3 June 2013

Re: Expansion of the SITA Kemps Creek AWT Facility (SSD-5275)

I write in response to your letter dated 26 April 2013 in relation to the Notice of Exhibition of the Expansion of the SITA Kemps Creek AWT Facility. Council is generally supportive of the proposed expansion. Council does however raise a number of environmental concerns that require detailed assessment by the department.

Figure 4: Existing layout of Elizabeth Drive and Resource Recovery Precinct Access Road intersection

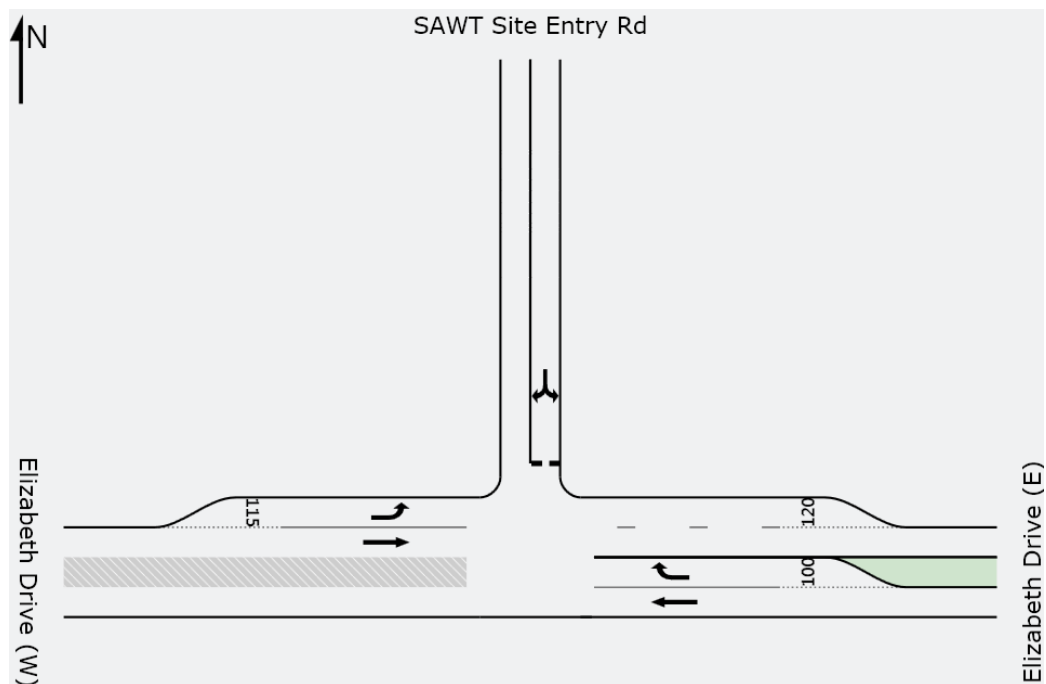
The intersection performance analysis has however identified that the existing Elizabeth Drive/Resource Recovery Precinct Road intersection which has a channelised right turn bay (CHR) would be expected to operate with level of service (LoS) C from the current level of service LoS B. The RMS has previously advised the applicant to upgrade the existing intersection to a seagull island which includes a westbound storage bay. This upgrade is included in the development proposal. Should the development be approved, Council recommends that an appropriate condition be imposed to require this intersection treatment to be carried out.

- Parking for employees and construction vehicles on-site.
 - Strategies to encourage employees to travel to the site by car-pool where possible.
2. The existing intersection off Elizabeth Drive to be upgraded to a seagull island which would include westbound storage bay. The intersection upgrade is to be carried out in accordance with RMS requirements.
